Your Ref: OWPC20026
Our Ref: R/188/18/HH 25-07-2018
Please ask for:
Zac Denton

One & two storey extension to (South) side & rear (East)
81 Sea Avenue Rustington

Thank you for your internet representation made on 22nd September 2018 which has been recorded as '**an objection**' with the comments as follows:

EXISTING FLOOR PLANS, ELEVATIONS,
ROOF PLAN & LOCATION
81 Sea Avenue
Rustington
West Sussex
BN16 2DR

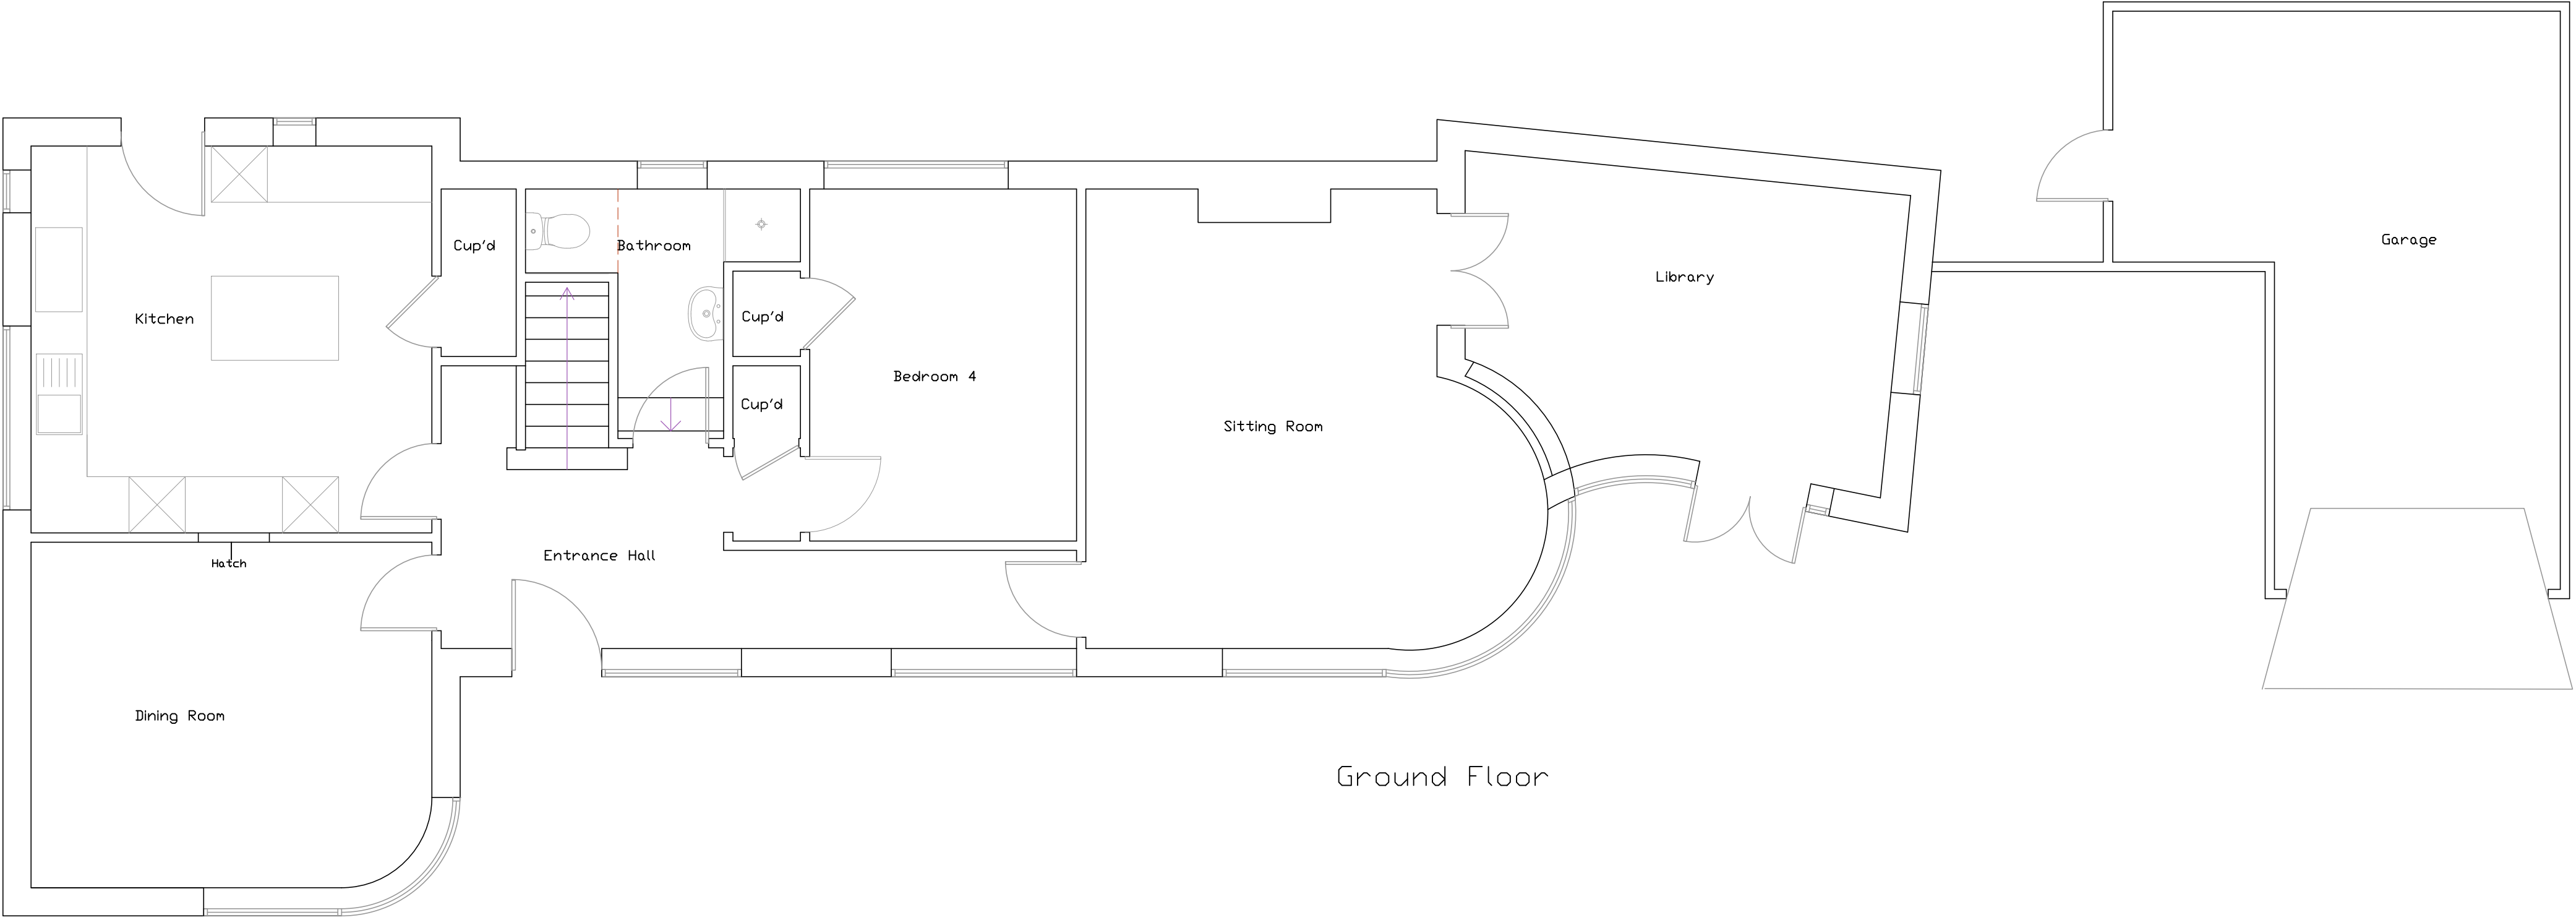
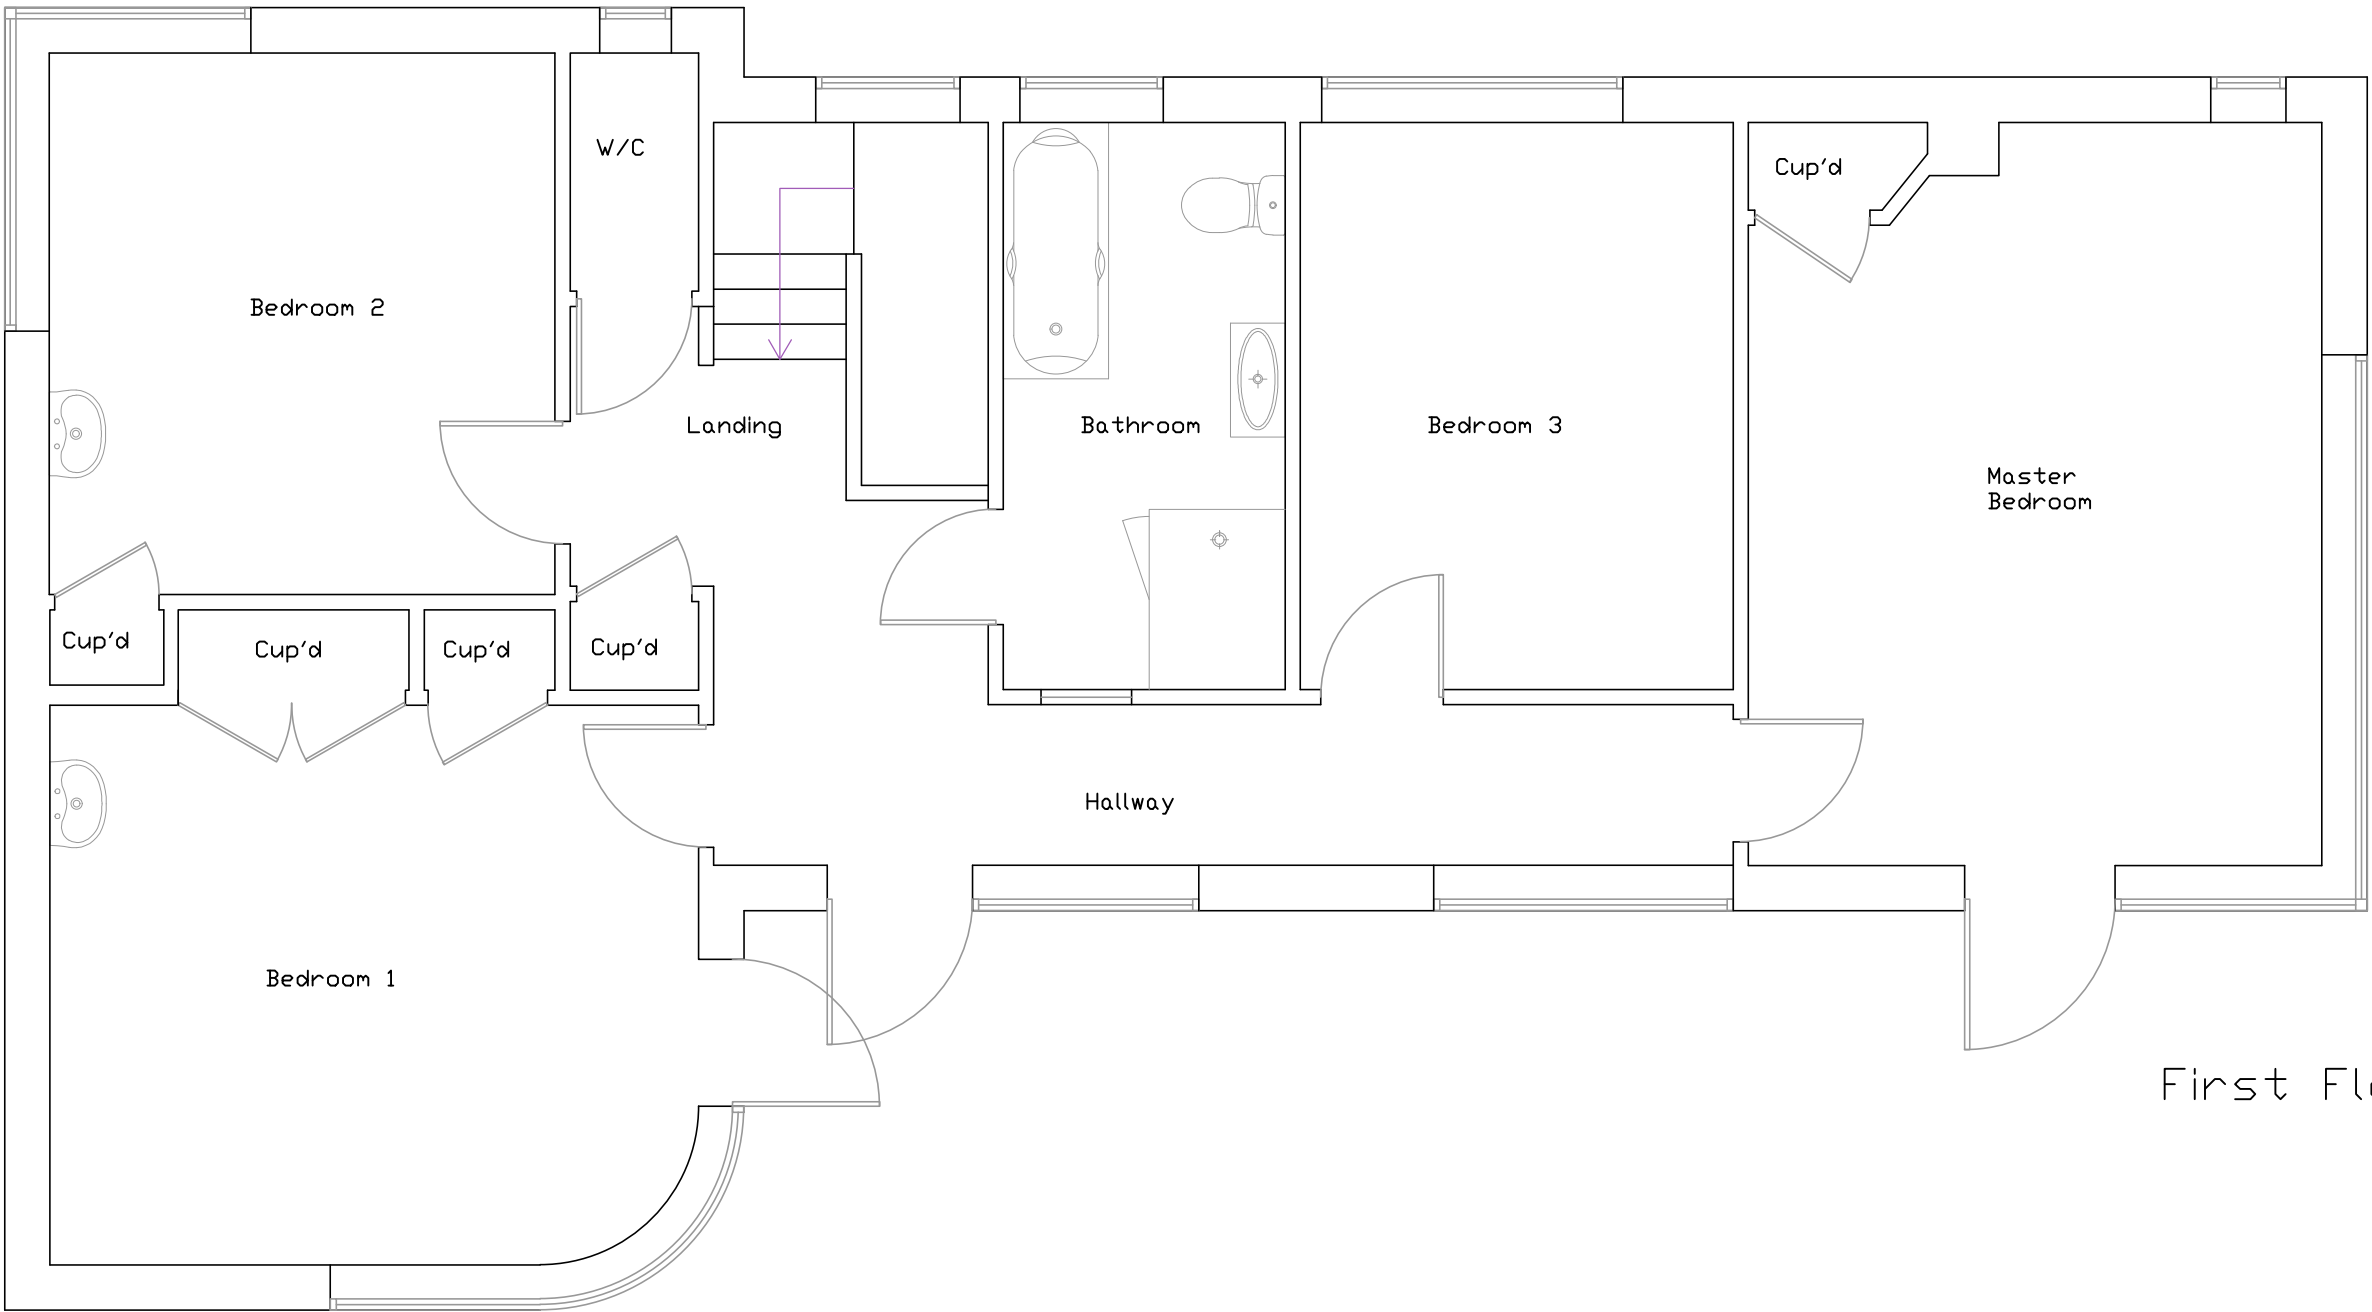
The plans as submitted are inaccurate. They have been copied directly from the very similar application lodged in 2015. Ref R/114/15/HH.

In the intervening period, there have been material changes to the North elevation and garden area. In addition, an interior wall has been removed. It would seem that the agent has not updated the site plans.
